Consultation Response from KC Highways
2019/90467 Highfields Centre, New North Road, Huddersfield, HD1 5LS
Conversion of former college buildings into 33 apartments including demolition of link canopy, partial demolition of link building, erection of additional storey to link building, and internal and external alterations (Listed Building within a Conservation Area).
Date Responded:
13/03/2019
Responding Officer:
Ryan Kinder
Responding Ref:
K5-5SE/6

2019/90467 Highfields centre New North Road, Huddersfield.

San Pedro Properties Ltd
 Development of Former College Buildings to Residential Apartments
 Highfields, New North Road,
 Huddersfield, HD1 5LS
 Proposed Site Layout Plan

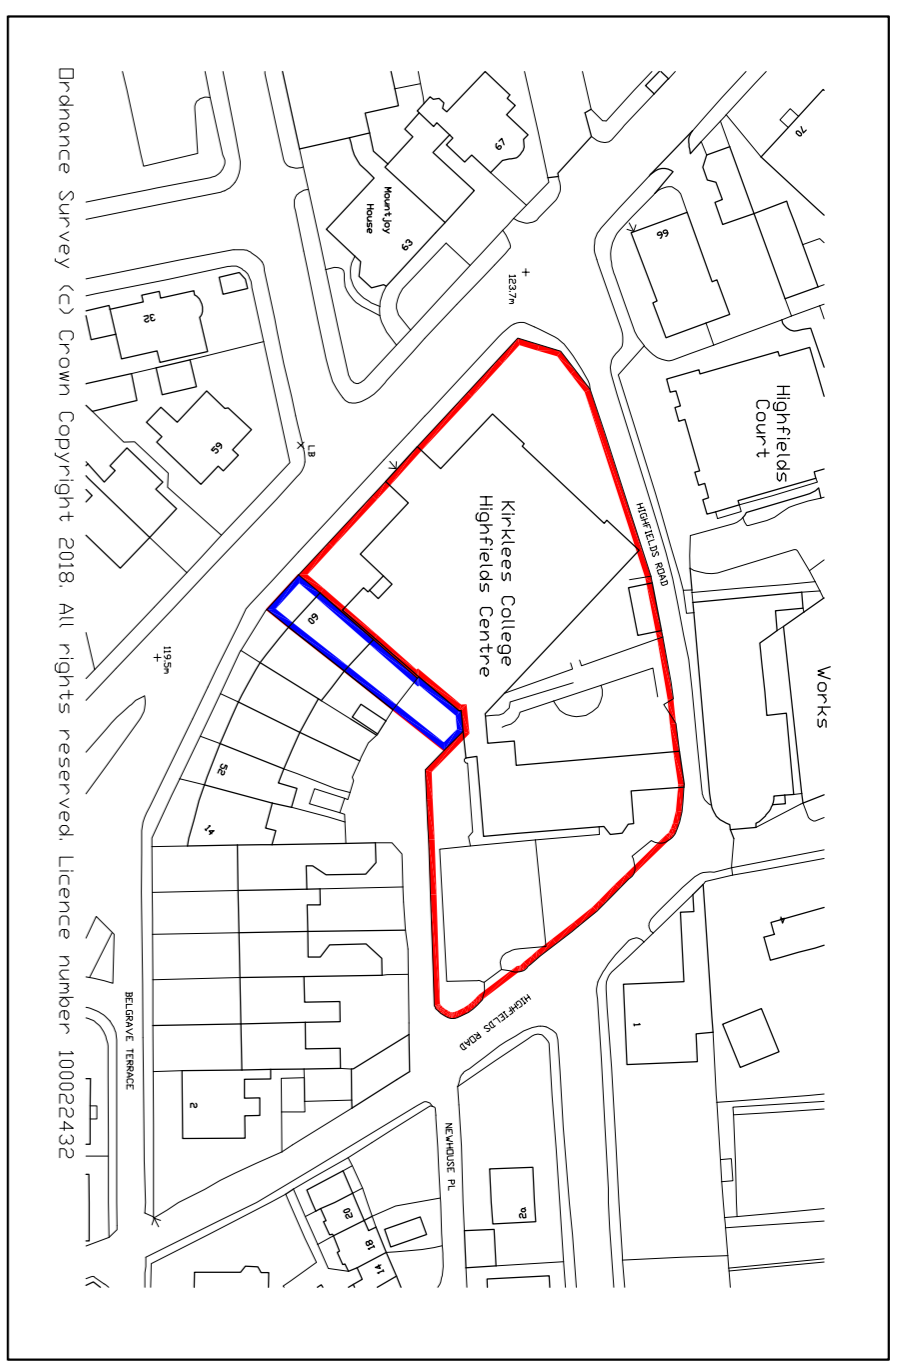
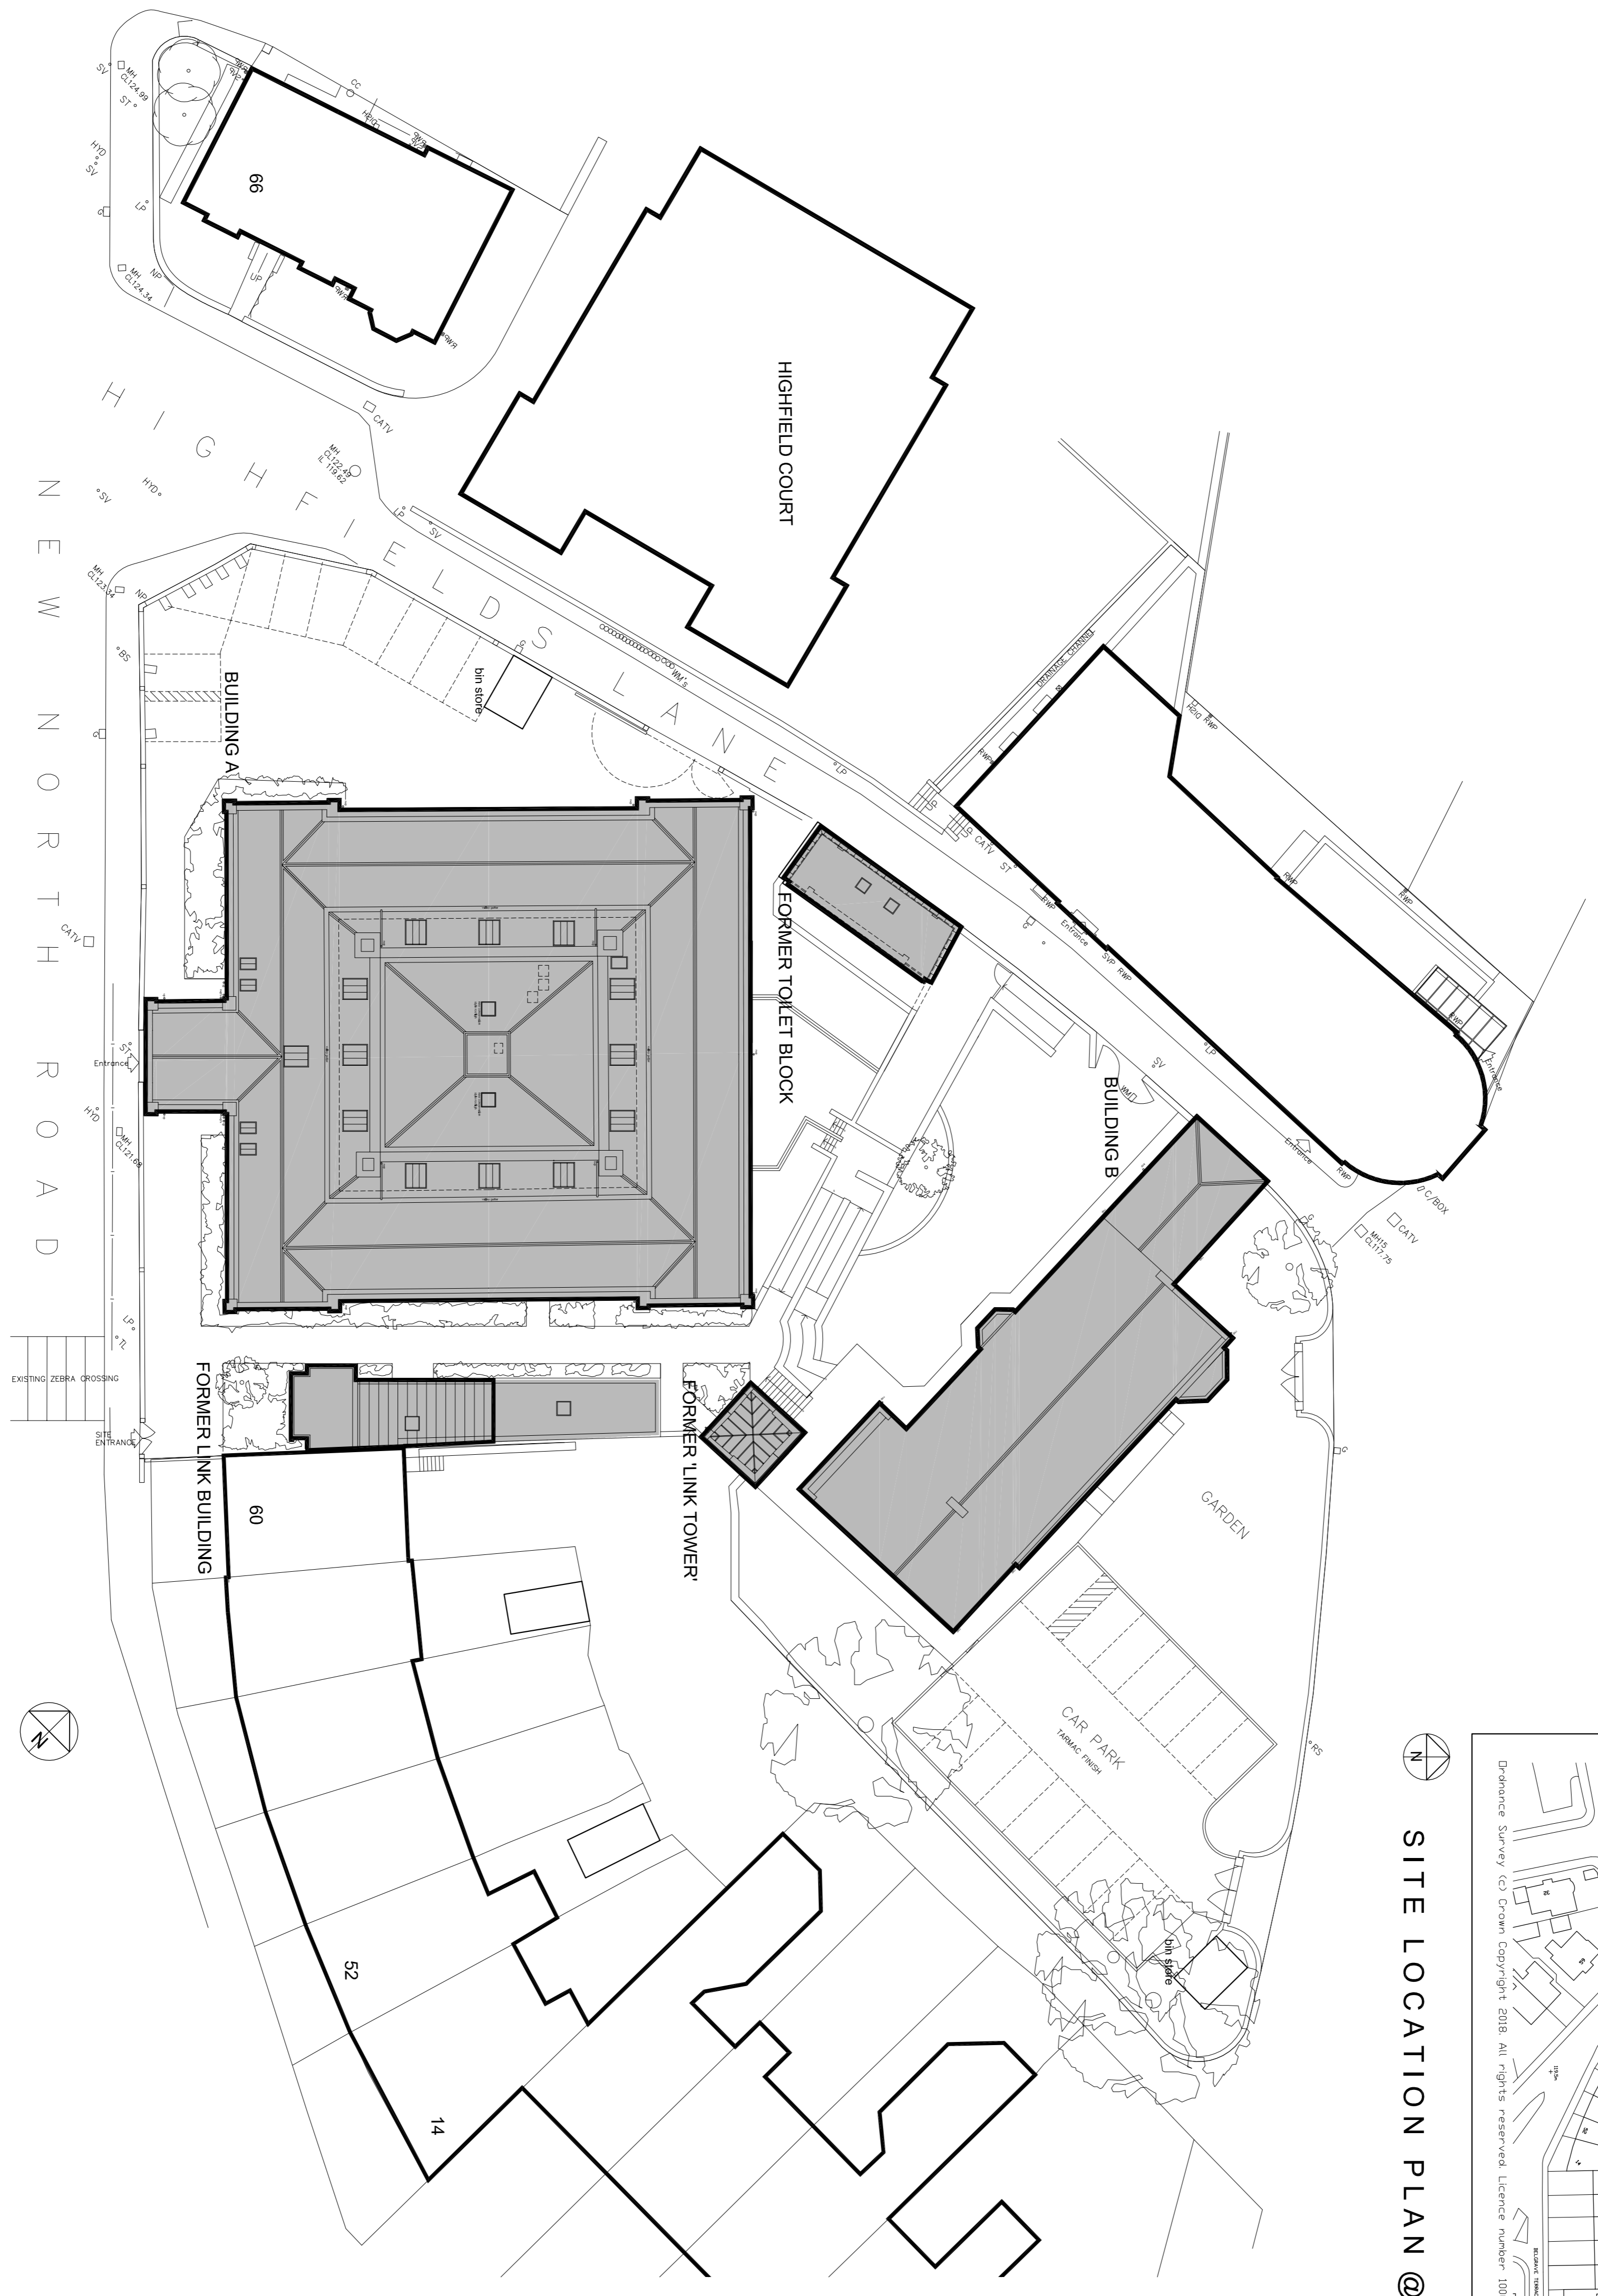
The width of the two access points should be of a minimum 4.5m to accommodate two way vehicle movements.

Concerns are raised over the available visibility currently achievable, suitable sightlines at both access points should be demonstrated.

The proposed site access taken at the most north western part of the site appears tight, swept paths should be demonstrated of turning manoeuvres at the site entrance.
